**Letter of Intent (LOI), Site Plan Letter (SPL), Criteria of Approval Letter (CAL)**

Property Address: 16888 Elbert Rd, Peyton, CO 80831

## Site Plan Letter (SPL)

# Site Map

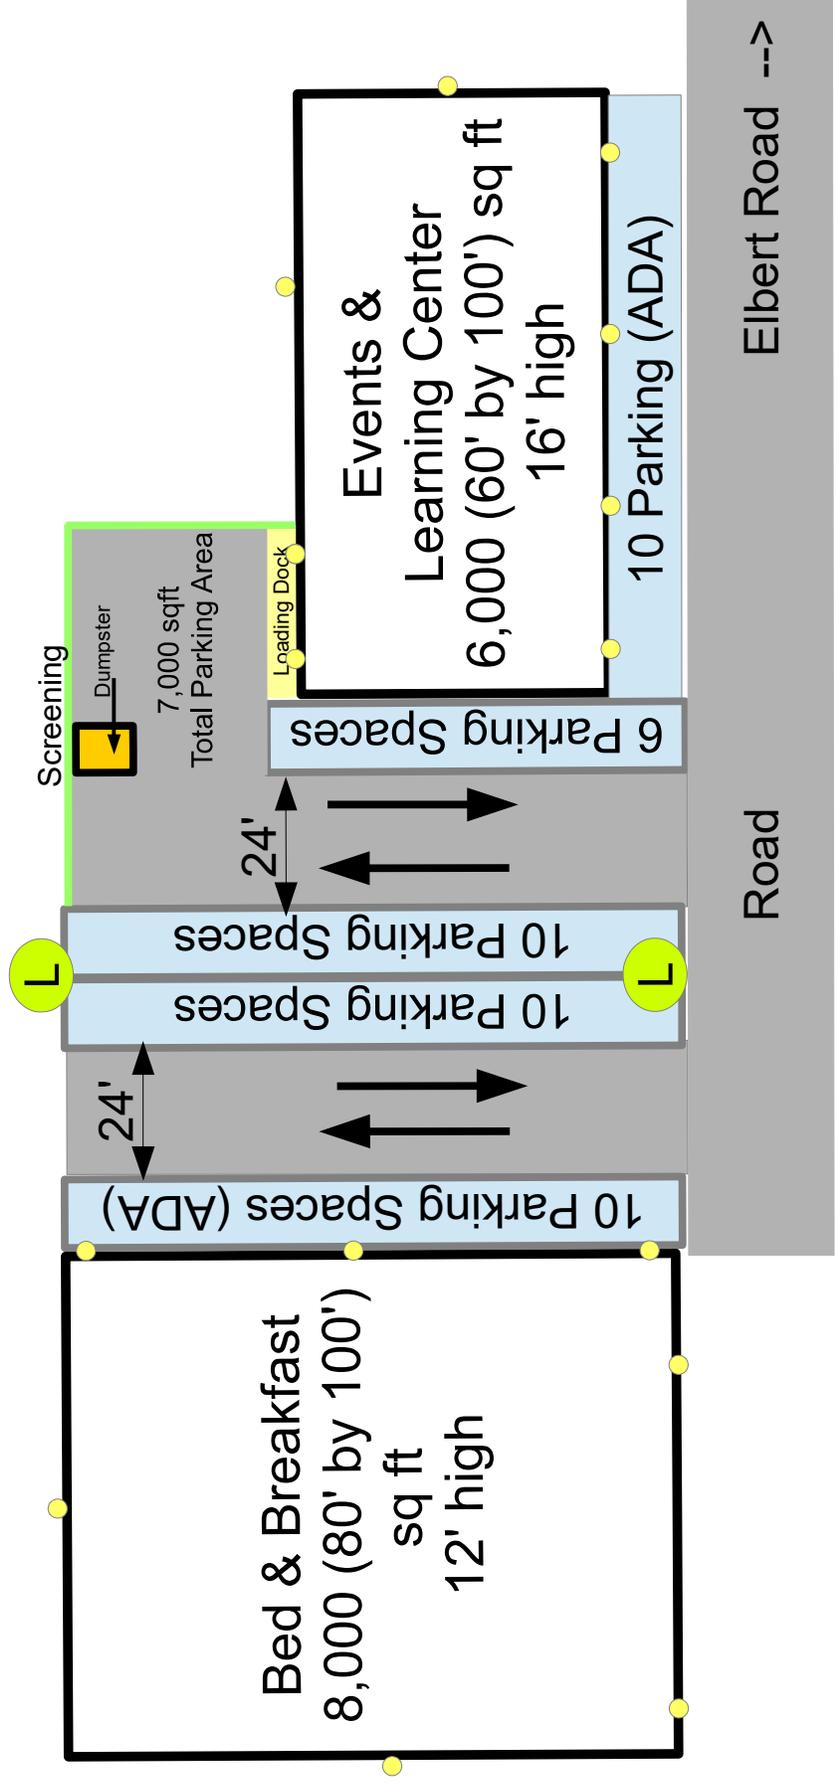
**Unresolved V1 comments:**  
**Please include:**  
 -Right of way dedication  
 -dimensions of parking, paved?  
 -location of outdoor illumination  
 -location of dumpsters/screening

These items need to be depicted on the site plan

Please depict the dimensions of the parking spots

Please depict dimensions and screening
